Hidden Valley Estates Plat - Long Plat App

ACTION REQUESTED: Board approval for chair signature on mylars granting final approval to the Hidden Valley Estates Plat (P-06-19)

Project Name: Hidden Valley Estates Plat P-06-19

In regards to the Hidden Valley Estates Final Mylar the following revisions are needed:

HIDDEN VALLEY ESTATES PLAT

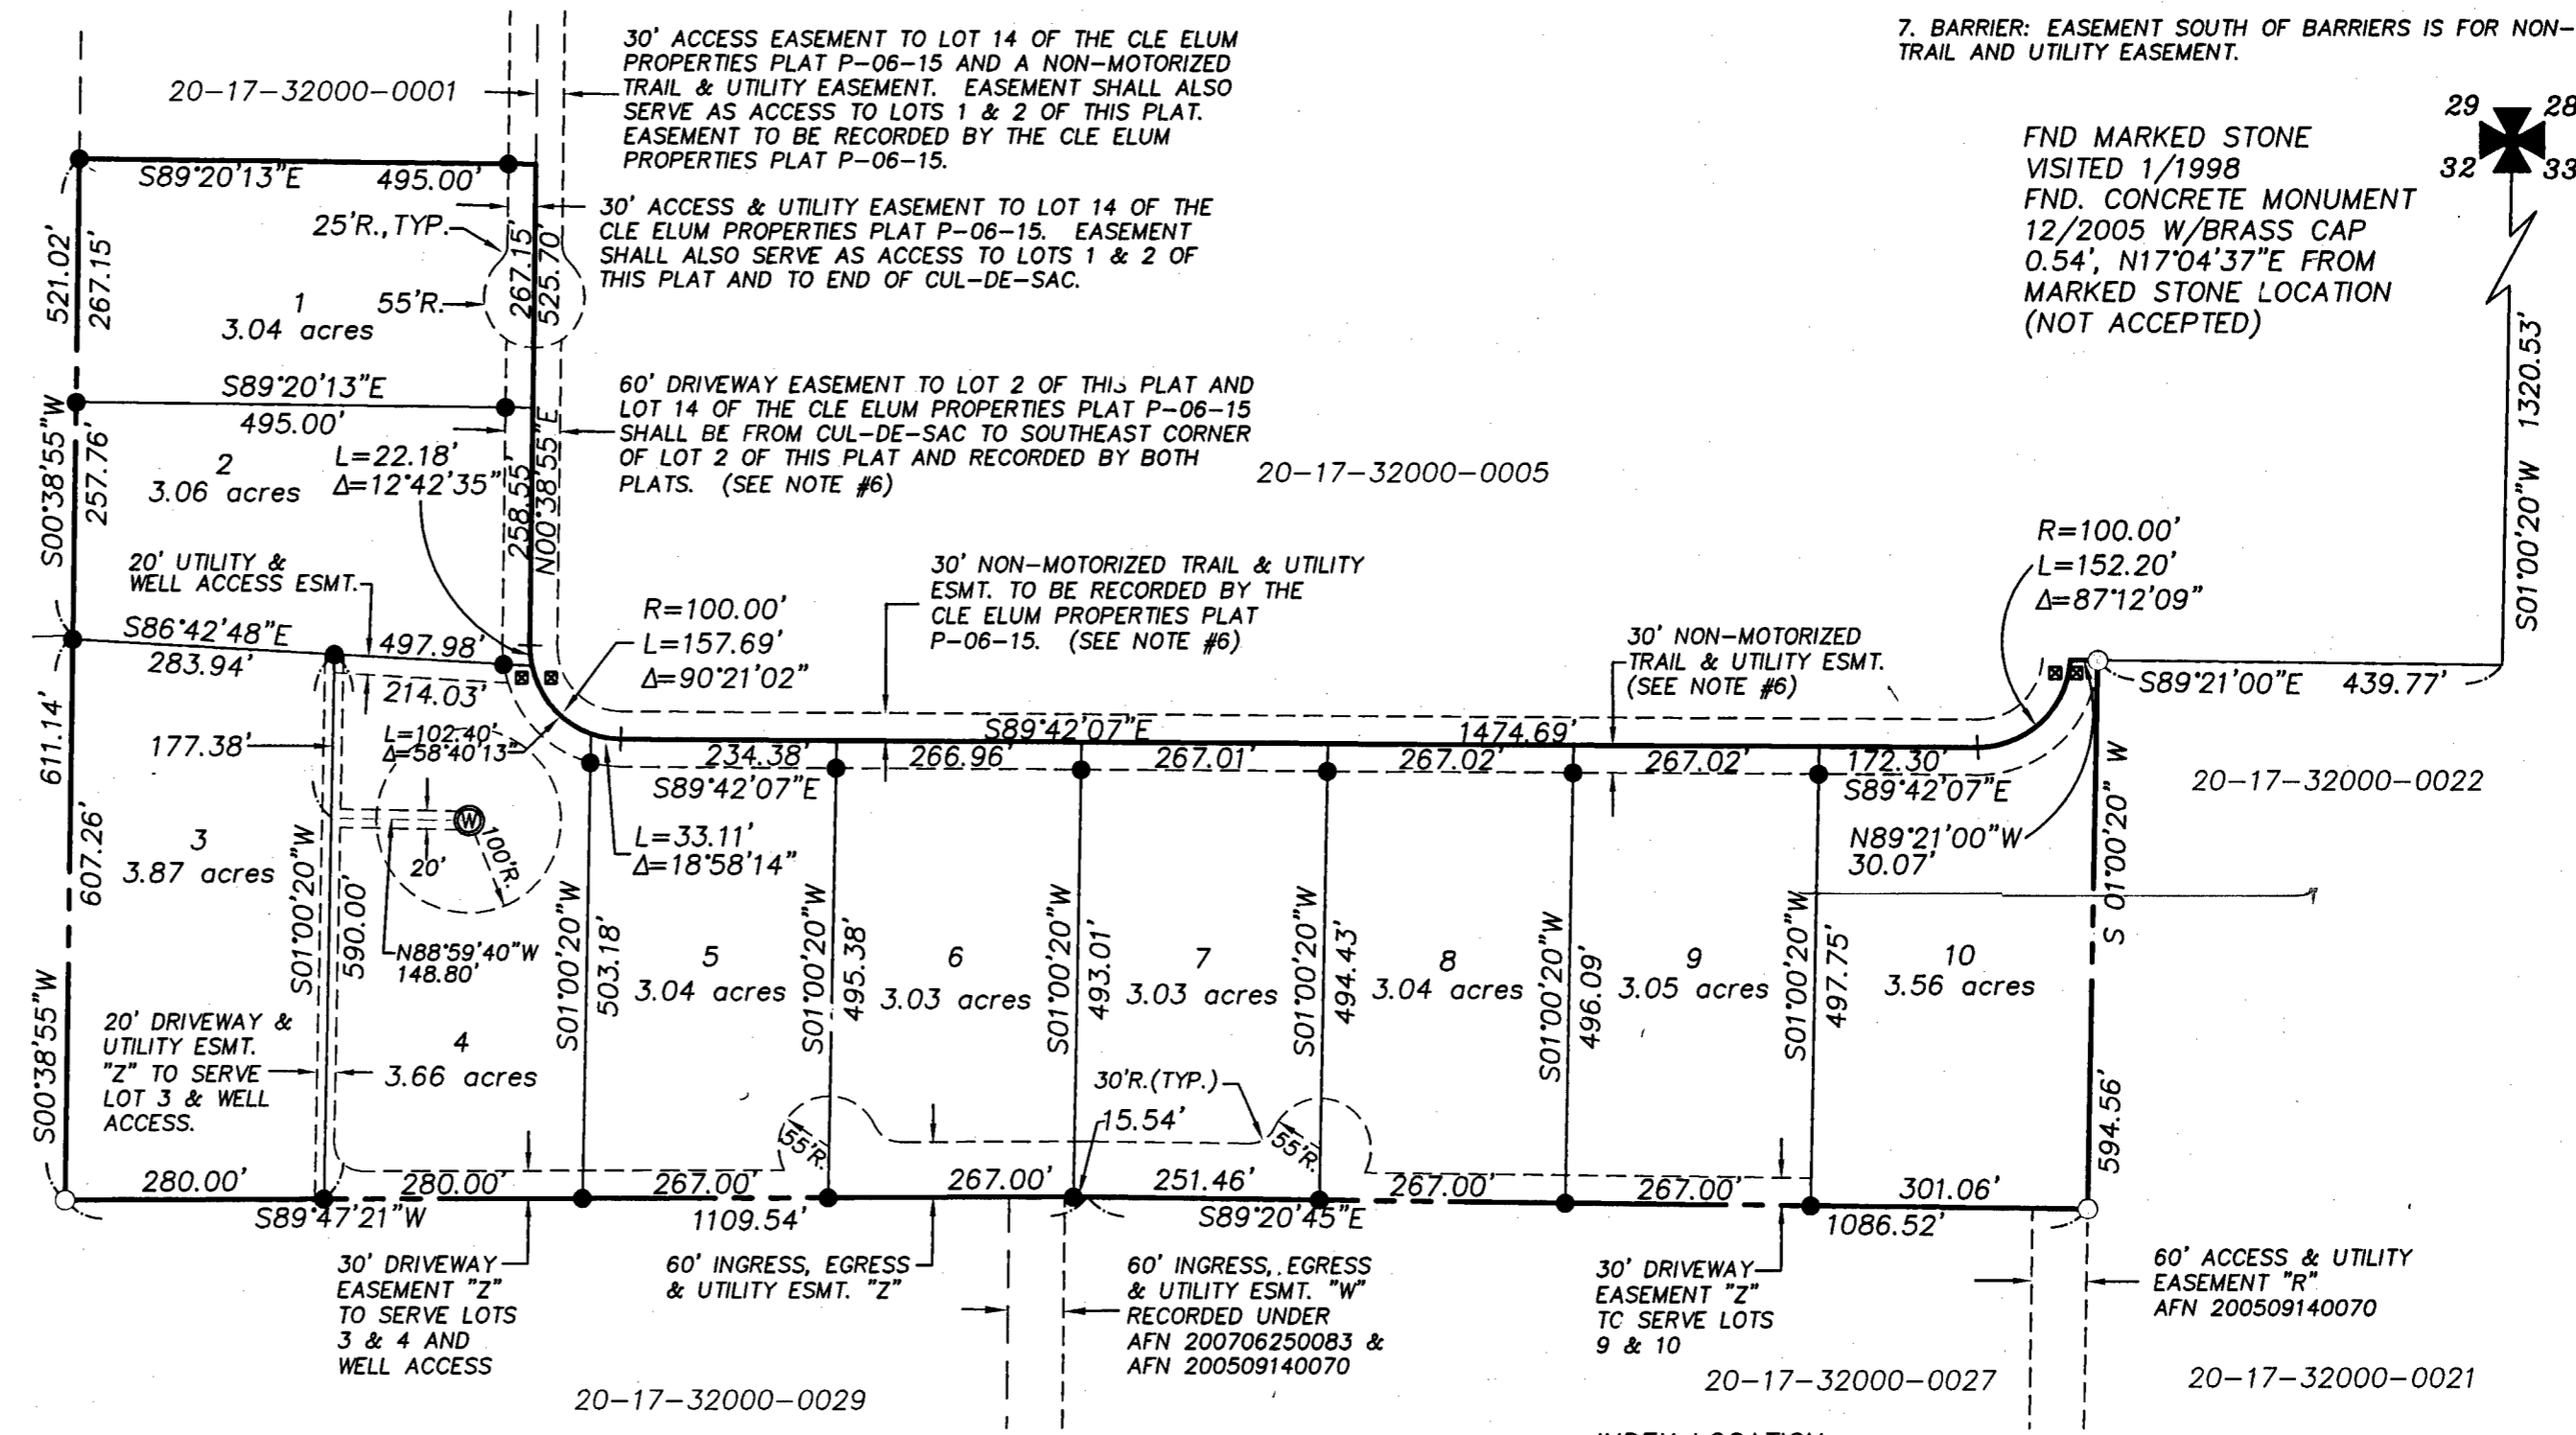
1. To clarify type of access to serve lots 14 and 2.

Replace current plat note "30' Non-motorized trail & utility easement. Easement shall also serve as access Lots 1 & 2 of this Plat. (See Note #6)" with "30' Easement restricted to vehicular access to Lot 14 of Cle Elum Properties Plat, P-06-15, and Lot 2 of Hidden Valley Estates Plat, P-06-19." SEE ATTACHMENT

The easement shall also be graphically distinguished from the underlying non-motorized trail and utility easement through the use of hashmarks/dots or other identifying marker.

2. To clarify location of Non-motorized trail and utility easement. SEE ATTACHMENT

Replace current plat note "30' access to lot 14 of the Cle Elum Properties Plat P-06-15 and a non-motorized trail and utility easement. Easement shall also serve as access to lots 1 & 2 of this plat (See note #6)" with "30' Non-motorized trail and utility easement."

The easement shall also be graphically distinguished from the overlay of the graphic used for the

30' easement for vehicular access to lots 14 and 2.

- 3. To clarify and distinguish the end of the vehicular access to lots 14 and 2 and separation from the two 30' non-motorized trail and utility easement (one 30' being recorded through Cle Elum properties and the other 30' being recorded through Hidden Valley Estates)

A barrier of some sort (i.e. bollards or other barrier) shall be placed near the southeast corner of Lot 2 across the easement and near the northeast corner of Lot 10 across the easement to distinguish the start of the non-motorized access. A graphic representation of the barrier shall be shown on the final mylar (can be also shown as a separate detail). A plat note shall be included referencing the graphical representations of the barrier, and the plat note shall state "Barrier: easement south of the barrier is for non-motorized trail and utility easement." THE SYMBOL HAS BEEN ADDED ALONG WITH A PLAT NOTE

- 4. Access to Lot 1 and depiction of Cle Elum Properties Cul-de-Sac.
Per the email below, the access to Lot 1 shall be revised to show access off of the Cle Elum Properties Cul-de-Sac. The Cul-de-sac shall be shown on the final mylar and shall be appropriately referenced. SEE ATTACHMENT

Thank you for your comments. Attached are pdf's of the revised plat per your comments. We did not follow your revisions exactly, but it will have the same result.
